**FINAL DRAINAGE REPORT
FOR
STERLING RANCH FILING NO. 5**

**December 2023
Project No. 25188.16
PCD Filing No: XX-XXX**

SWALE SECTION DP1  
SCALE: 1"=3'

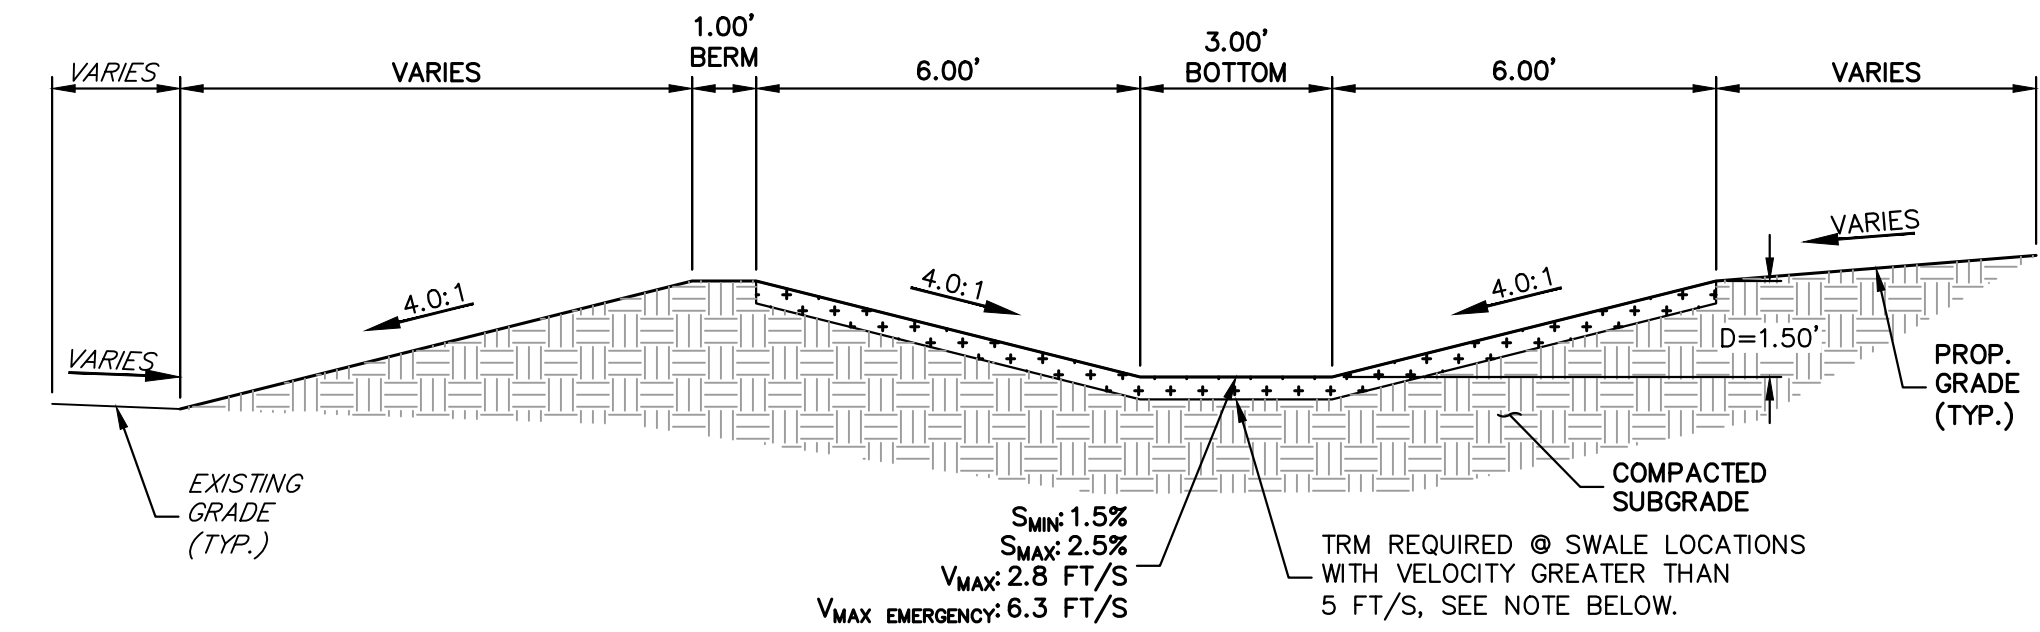
distinguish between "basin runoff flow" and emergency flows...two flows being analyzed, inlet calcs and swale calcs fusing....need this presentation of the spillway design over flow. lets discuss please.

how do we capture 8.3 cfs when basin flow issues? This inlet is part of basin A2? need flows here. need to know where the 7.3 cfs

Provide analysis of swale carrying overflow of 62.5 cfs

JR Response: Addressed.

JR Response: Analysis of swale carrying additional flow was provided. See DP3 Swale Emergency Pond Overflow calculations in Appendix C.
